OA2022/0009

12 December 2022

Subject: Request for Comments - State Significant Development (SSD)
Application No: SSD-9577613
Property: 554-562 Reservoir Road Prospect
Proposal: Expansion of the existing Americold refrigerated warehouse facility and additional supporting infrastructure including alterations to the site access, parking and loading arrangements Other Authority Consent - Americold Prospect South Expansion (SSD-9577613) - 554-562 Reservoir Rd Prospect NSW 2148

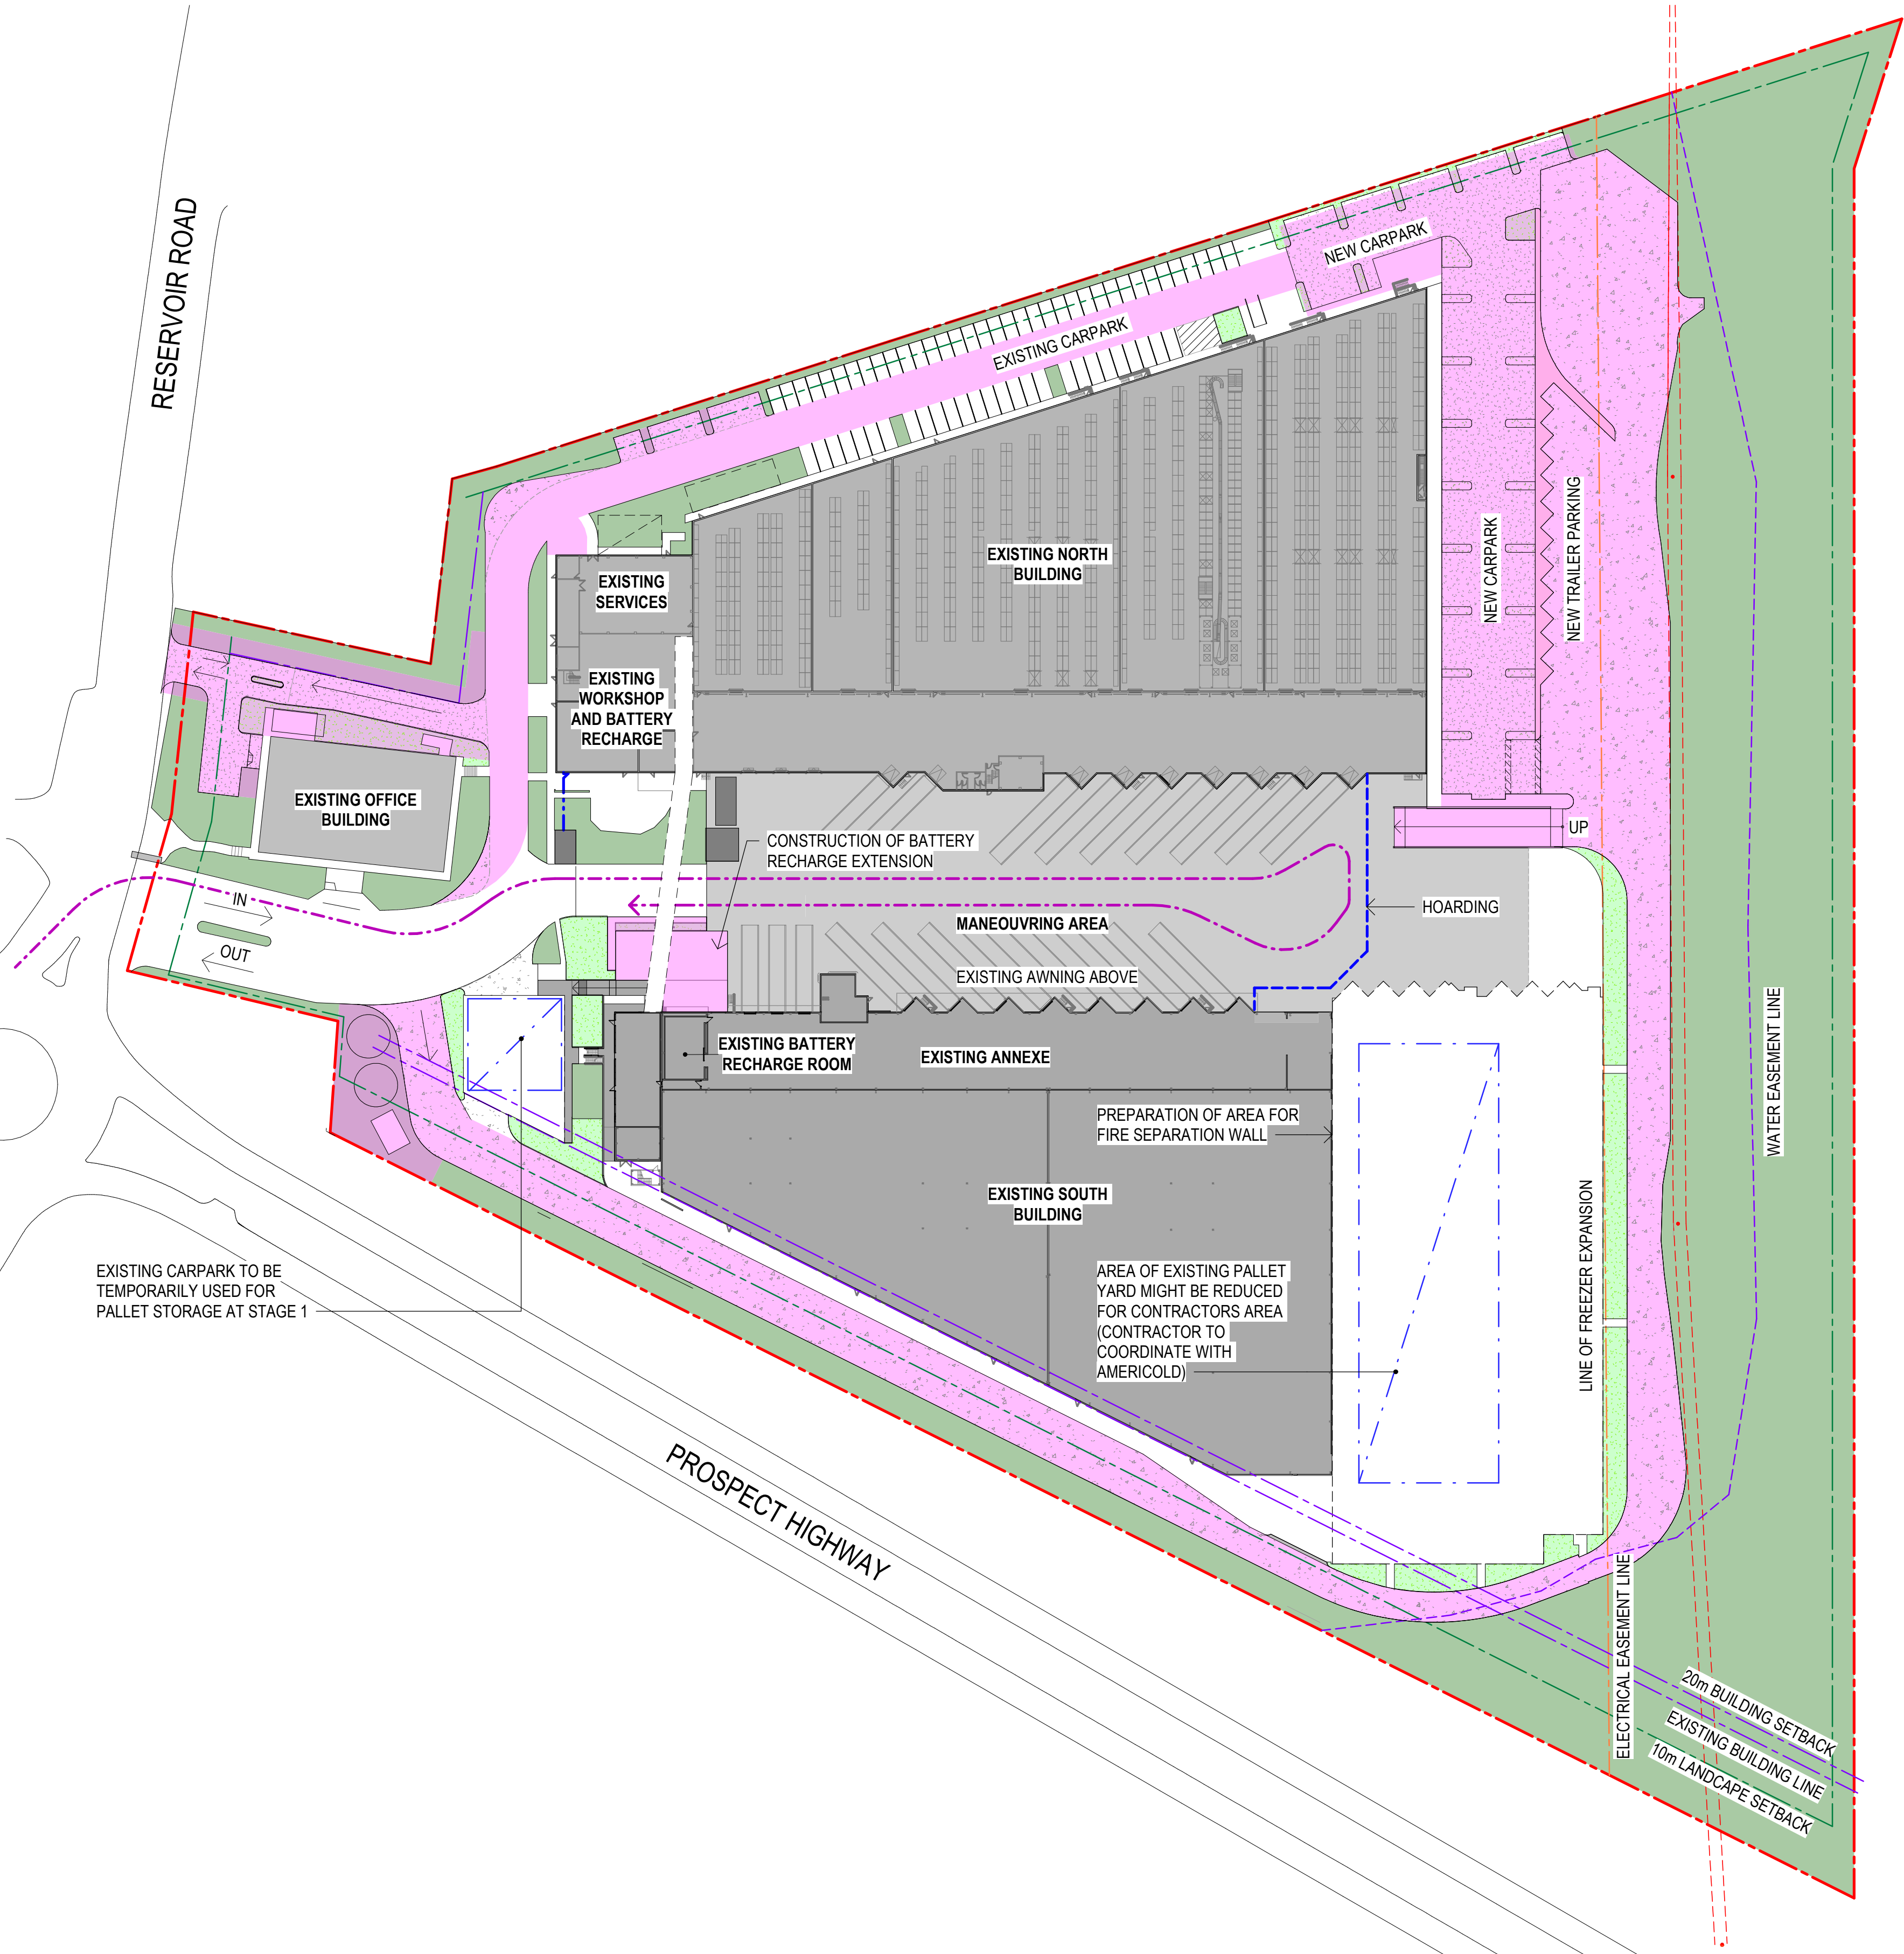
- v.) Each of the parking spaces must be appropriately numbered and dimensioned.
- vi.) The existing 21 visitor's car spaces that is proposed to be deleted must be made available from the new car parking area/provision and clearly marked and signposted.

Discipline	ARCHITECTURAL
Drawing No.	2527456-DA-4101
Rev.	E

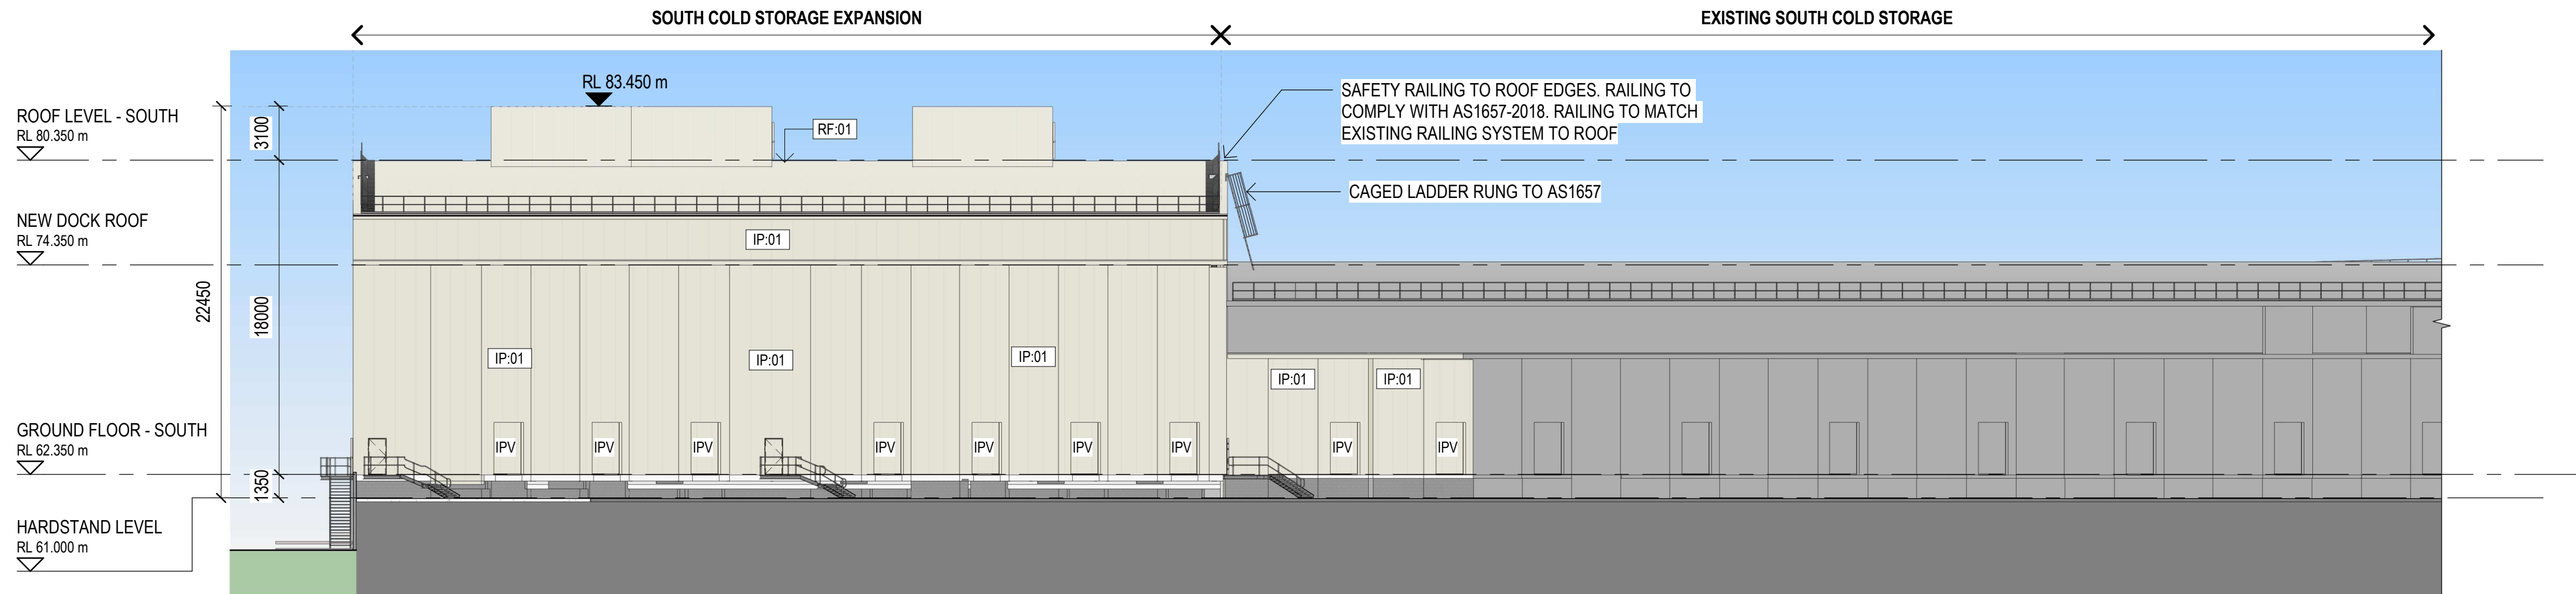
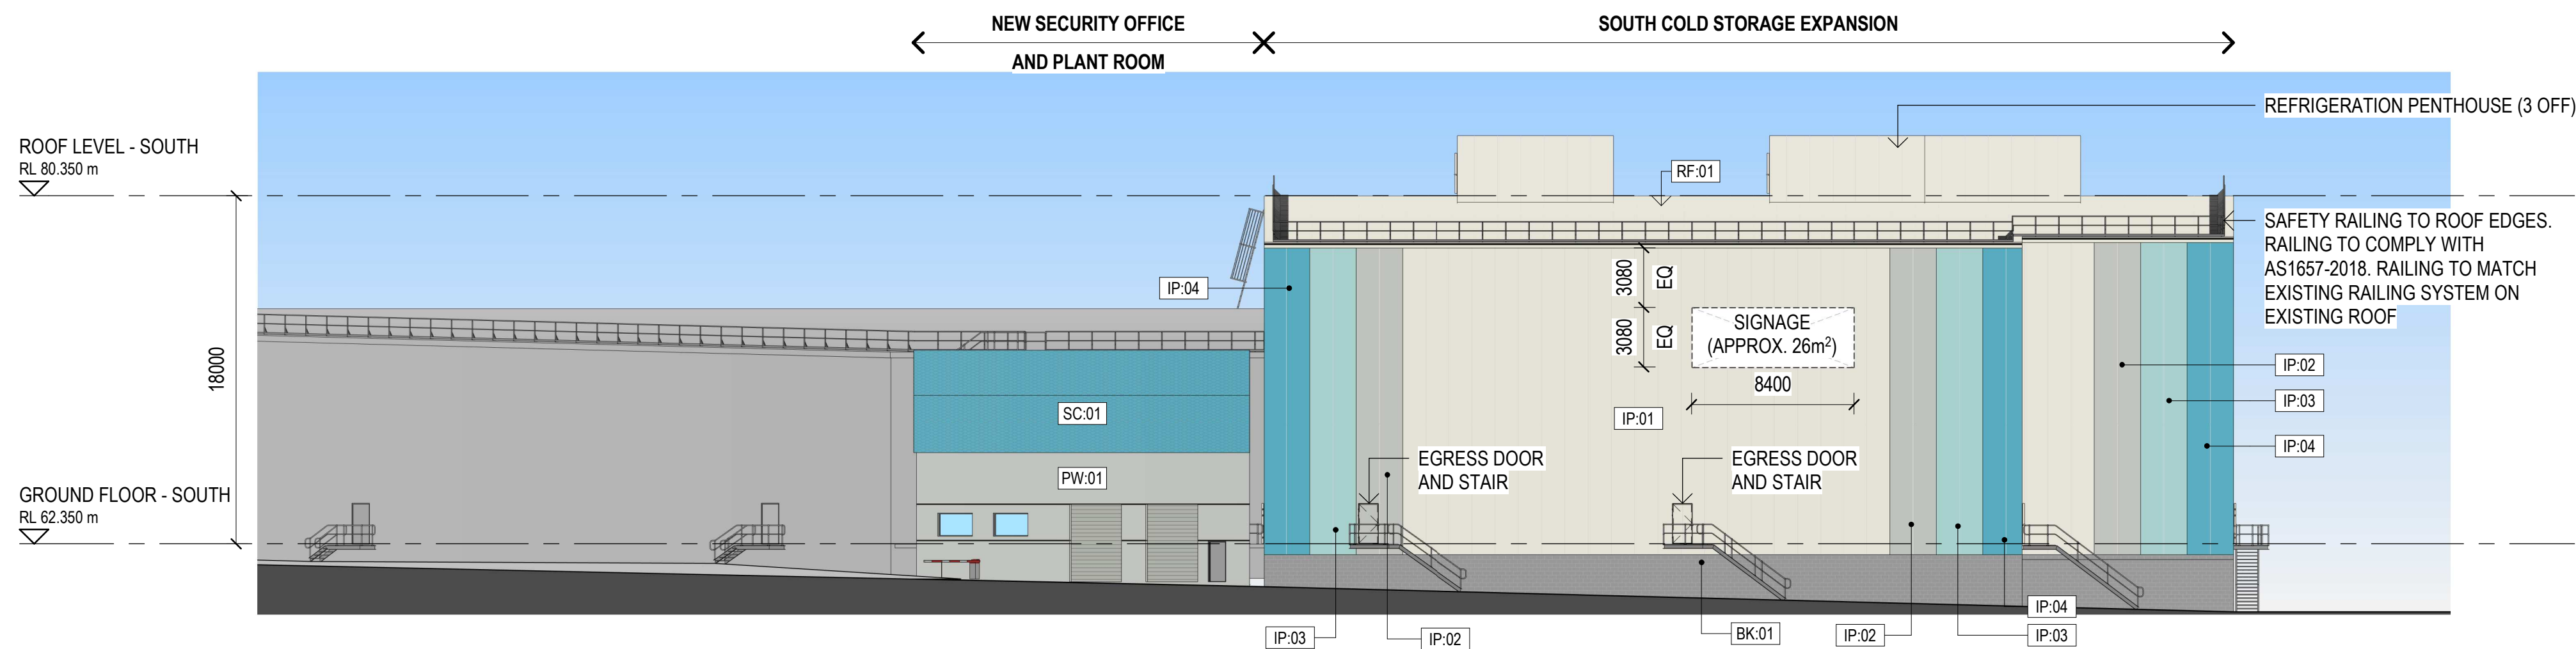
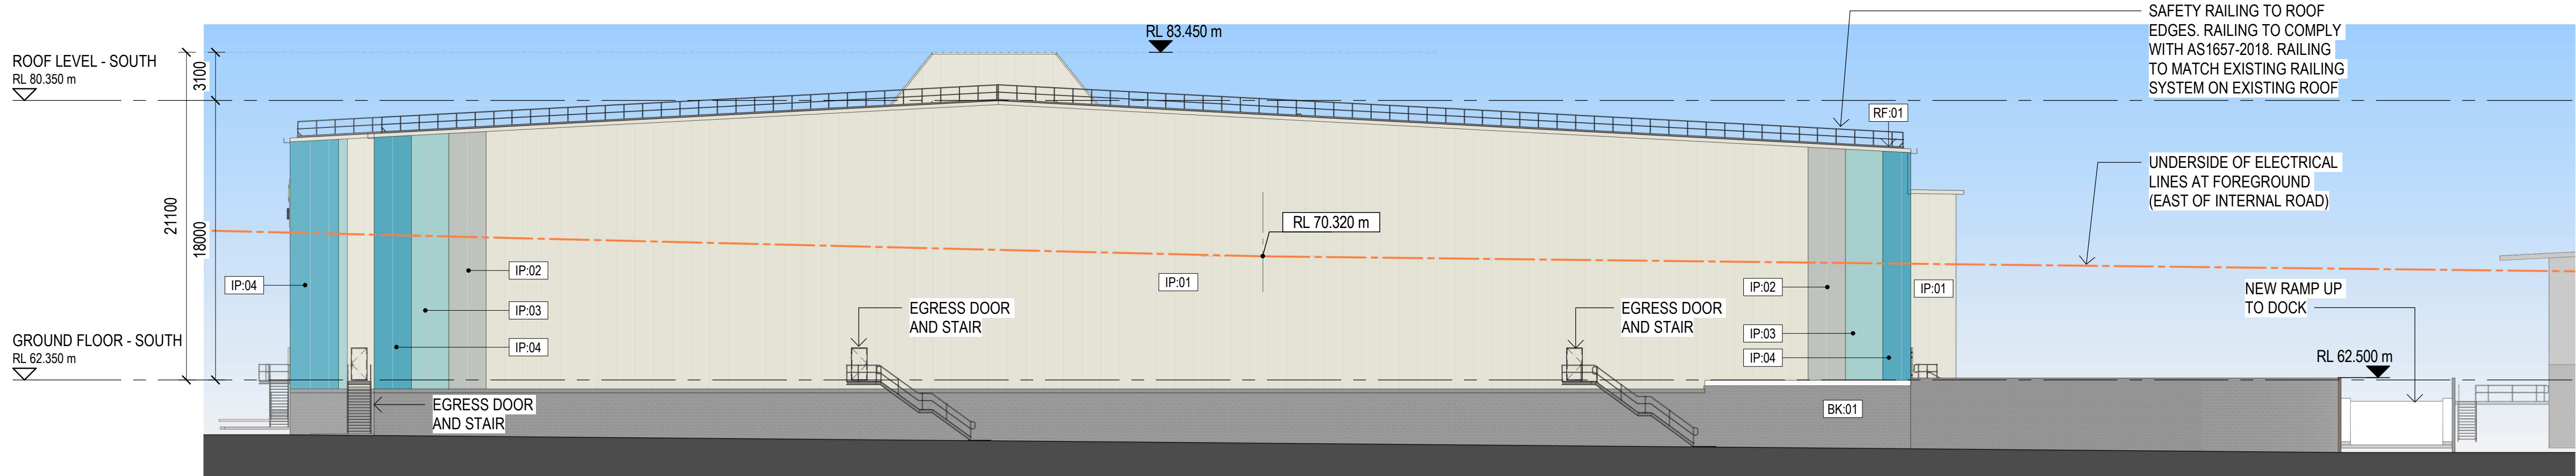
Given the proposed building (south cold storage expansion) proposes a significant height as compared to the existing building, the structure shall incorporate articulation in building facades and variety in building materials and finishes to minimise the overall visual impact of the proposed structures as viewed from the street and be sympathetic to the existing heritage site - the Prospect Hill State Heritage Registered area.

The overall design shall be compatible with the existing built form and streetscape in terms of façade treatment, building materials and finishes.
